**Application: SSI 7485**

I write regarding the proposed modification to M4-M5 Link, Mod 2 The Crescent overpass and changes to pedestrian infrastructure in North Annandale, Rozelle and Rozelle Bay Foreshore area.

**Figure 4 | Proposed modification** (Source: Design Amendment Report)

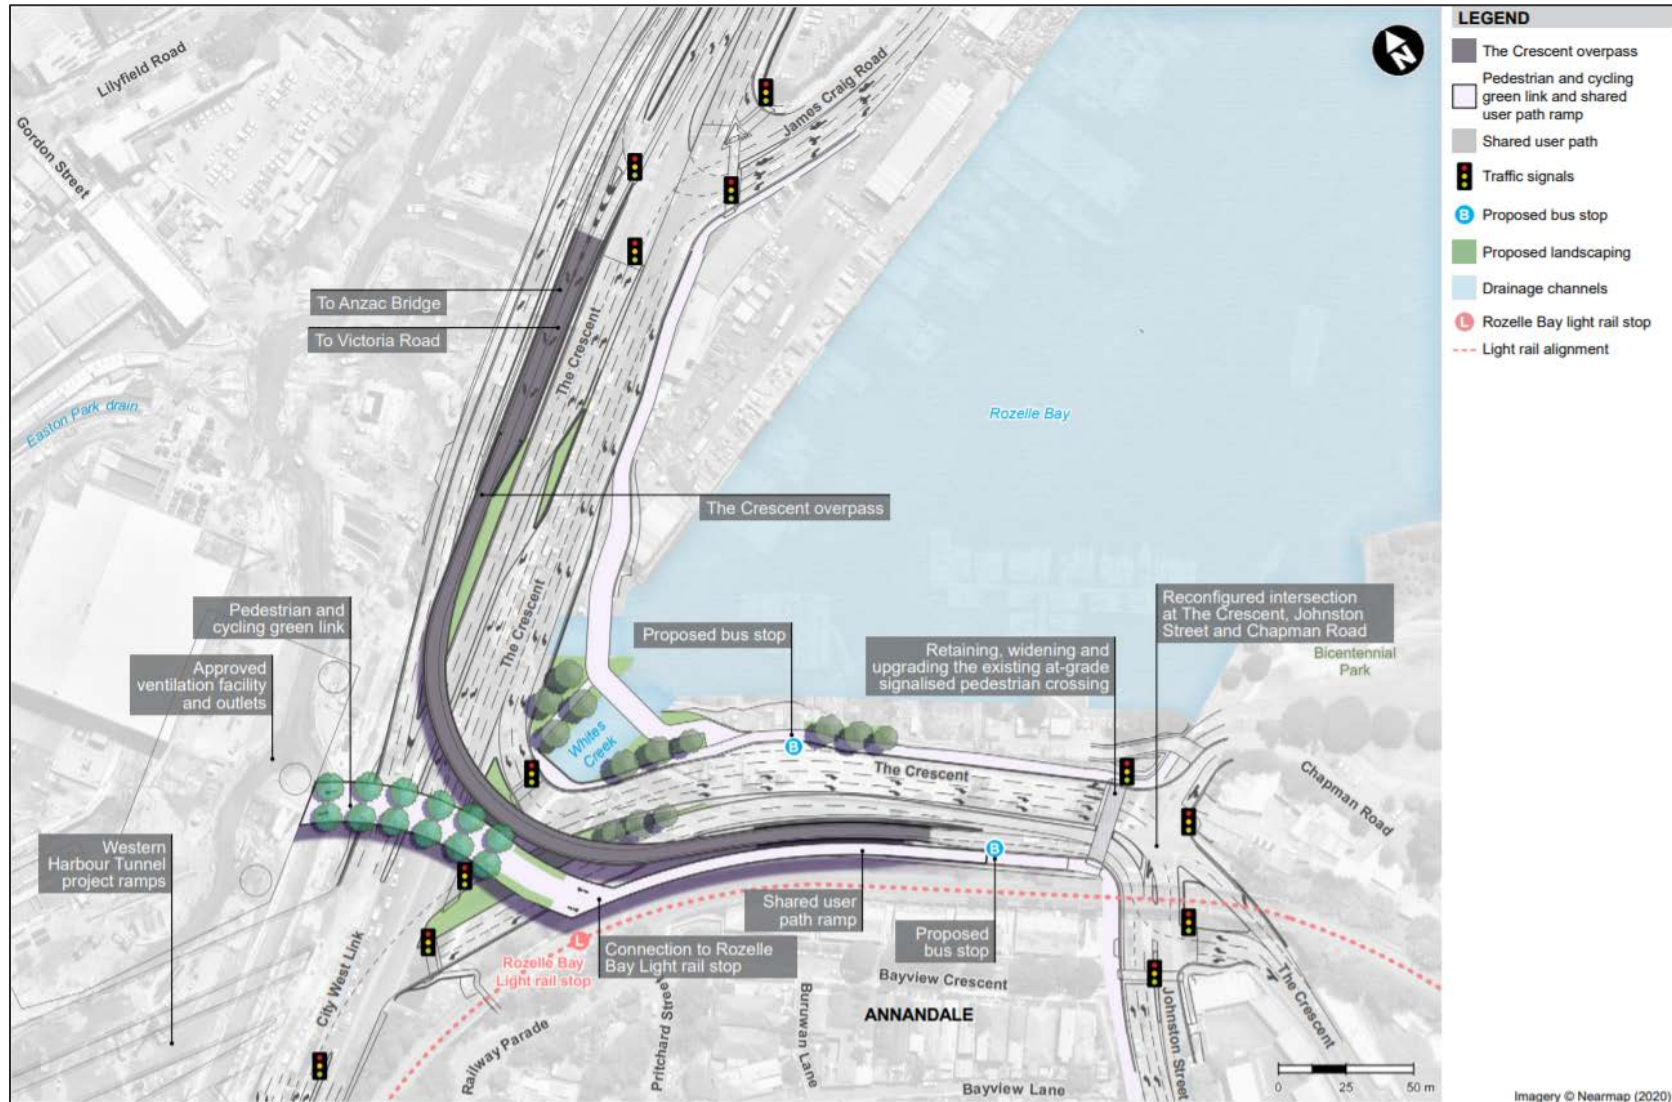
I request RMS work with the community to explore alternate design options to the proposed new car overpass design and the changed pedestrian and cyclist links. I am seeking the reinstatement of the safe, direct access from the approved EIS GreenLink to create a continuous green open space connection from the Rozelle Rail yards and Annandale to the foreshore. The GreenLink was more than just a walk way - it put people central to the design, maximising safety, and providing much needed accessible open space for the community now and into the future Bays Precinct design.

- The significantly reduced safety and increased risk for pedestrians and cyclists with removed access over The Crescent to Bicentennial Park and the increased traffic along Johnson Street.
- Being required to cross five sets of pedestrian lights at The Crescent as my option to reach the foreshore from Annandale or from Rozelle Bay light rail stop.
- Removal of direct active links to the foreshore, cutting the community off from the area and the proposed revitalisation of the entire Bays Precinct, including linking the Light Rail and Bus stops to a Ferry wharf and Metro station.
- Urban and landscape design that is being built before a finalised Masterplan for the area.
- Traffic changes that limit movements around the suburb and create further congestion in the local streets of Annandale, Forest Lodge, Glebe, Lilyfield and Rozelle with no planning to deal with these.

- Reinstate the GreenLink connecting communities and green open space from Rozelle to Bicentennial Park
- Relocate and design pedestrian and cyclist connections that are continuous, safe and direct.
- Design the modification infrastructure and active links in response to the character of the suburbs, the location of the foreshore and it's potential future development.
- Provide pedestrian and cyclist paths that maximise people safety and do not force them onto busier streets, unsafe concrete plazas and caged walkways.
- Integrate active and direct connections to all active transport - including the future Metro West and Foreshore Ferry Wharf
